Our Ref: TR050007

Date: 07 March 2023

### **Application by Tritax Symmetry (Hinckley) Limited for an Order Granting Development Consent for the Hinckley National Rail Freight Interchange**

#### **Advice to Applicant following withdrawal of application**

Annex 1 ◆ SCO Site Location in Relation to Relevant  
International/European Designated Sites  
(edp3267\_d179 09 March 2023 DJo/MNe)

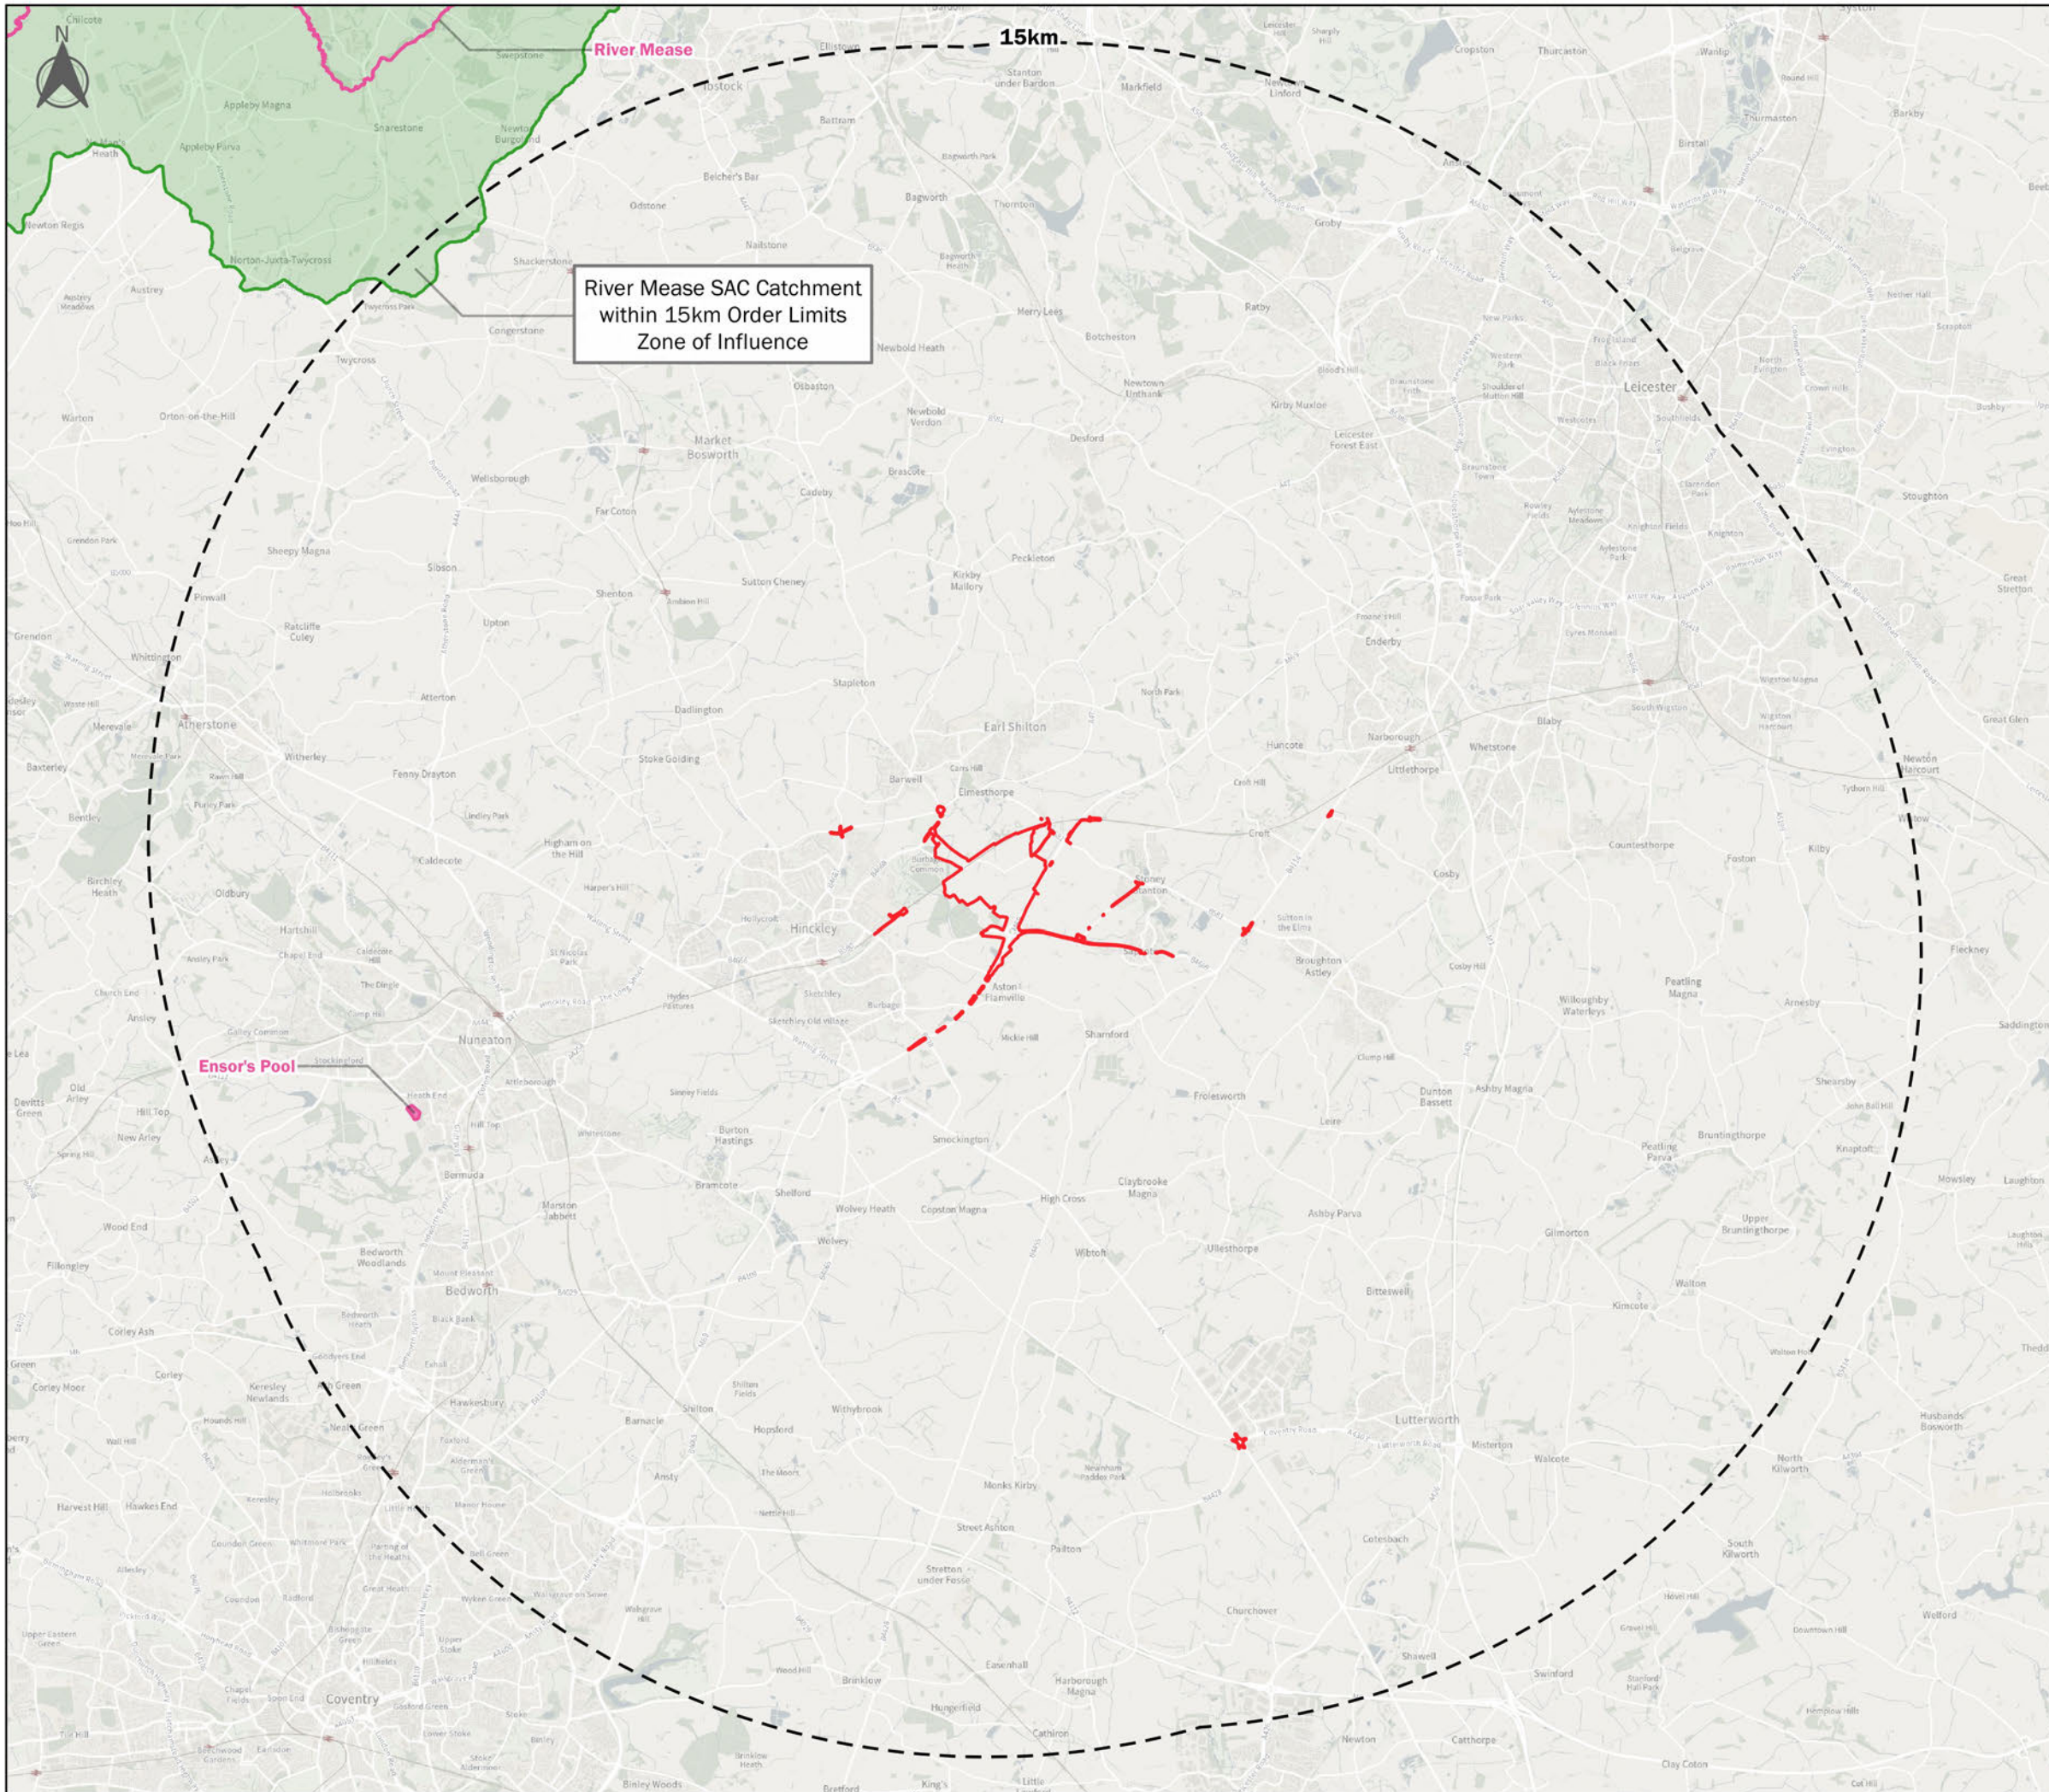
- 5.1. Regulation 5(2)(l) of the Infrastructure Planning (Applications: Prescribed Forms and Procedure) Regulations 2009 (the APFP Regulations) requires:
- “Where applicable, a plan with accompanying information identifying:-
- any statutory or non-statutory sites or features of nature conservation eg sites of geological or landscape importance;
- 5.2. ES Figure 12.1 Statutory Designated Sites does not show the Special Areas of Conservation screened into the Shadow Habitats Regulation Assessment (sHRA) (Appendix 12.3 of the ES) and the sHRA also does not provide a figure showing the location of the relevant habitat sites cited.
- 5.3. The Applicant must provide a plan identifying European statutory designated sites.

Drawing file: TR050007 / TR050007-001033-2.7B Hinckley NRFI Speed Limit Plans [sheet 2 of 3].pdf

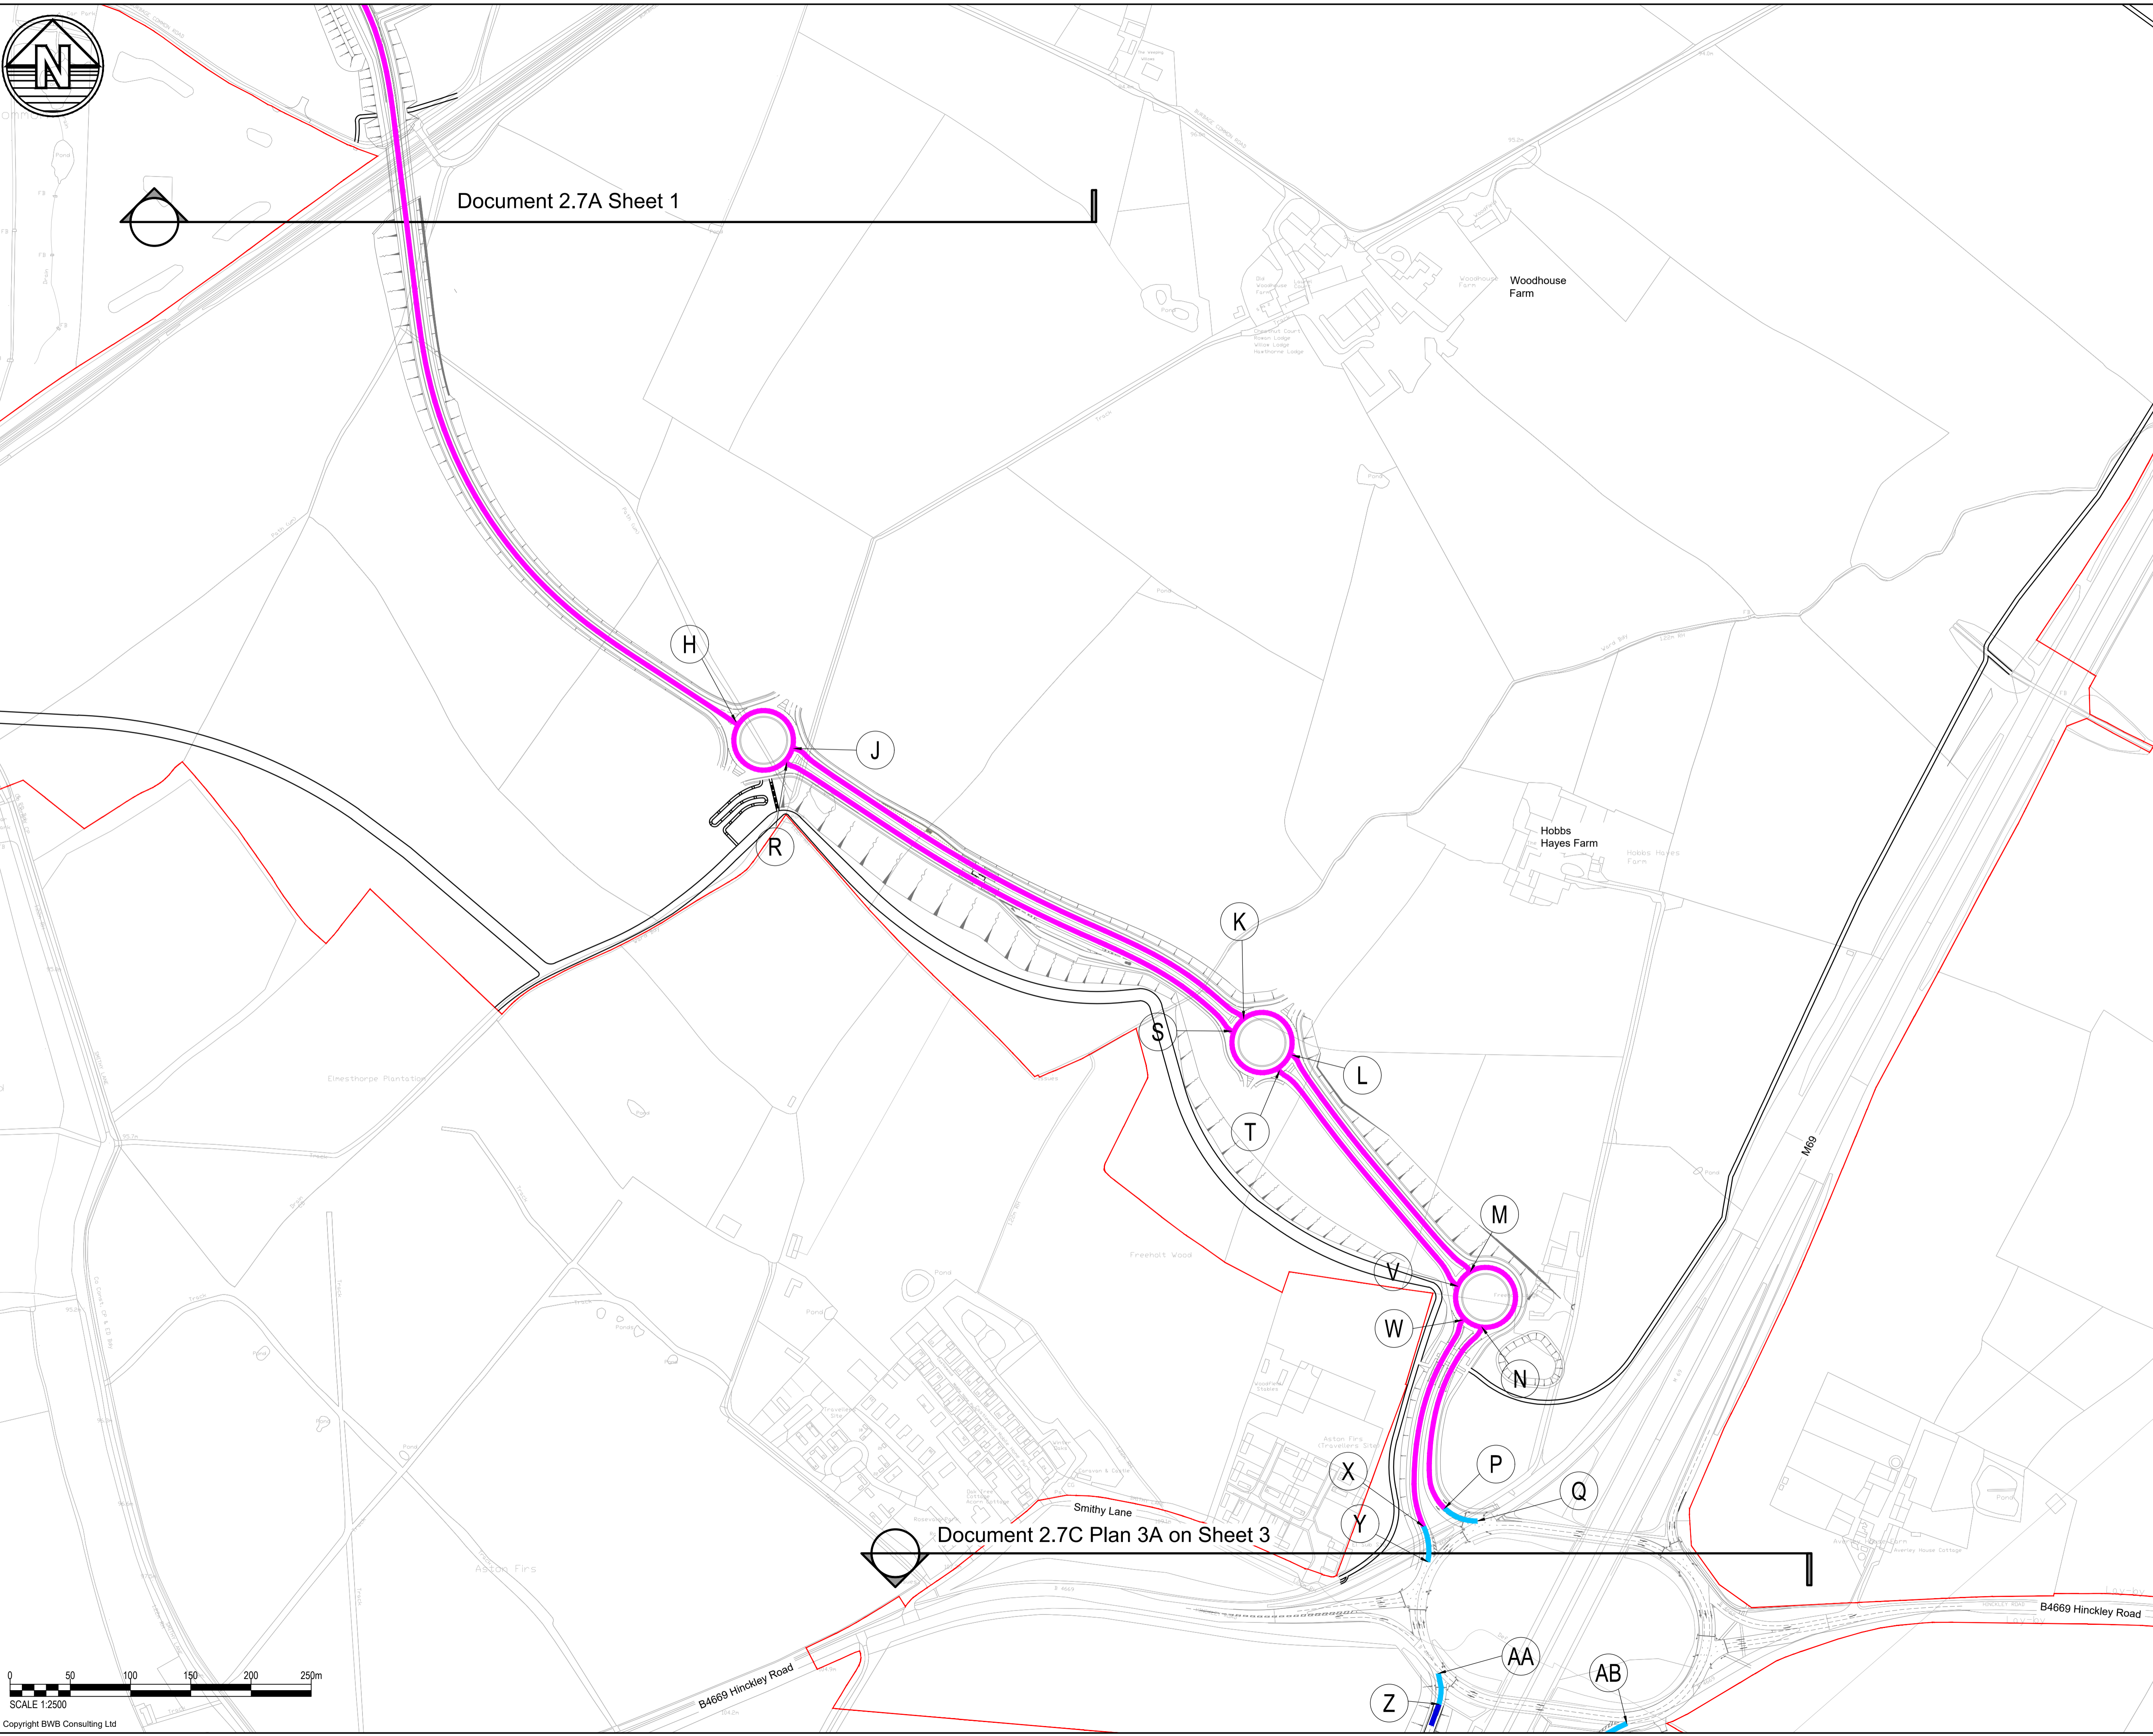
- 7.13. Although the key indicates that an existing order is amended, it is not clear how this would apply. While Schedule 8, Part 1 of the DCO sets out the change, there do not appear to be any highways marked "LOCAL HIGHWAY WITH 50MPH SPEED LIMIT EXISTING ORDER AS AMENDED BY THIS ORDER" on the Speed Limit Plans.
- 7.14. Colours on legends visible in plans going outside order limits and without labelling, for example sheet one – Orange dashed line, no speed limit is given for plot to south west of the Order Limits and stops as high as Solid pink line at A with no indication for the roundabout.
- 7.15. In Schedule 8, part 3 of the DCO (Doc 3.1) there is reference to the speed limit on Documents 2.7B and 2.7C. However, between points AA and Z and AB and AC appears to be below the cut line for sheet 2 so should only be referred as being on sheet 3.
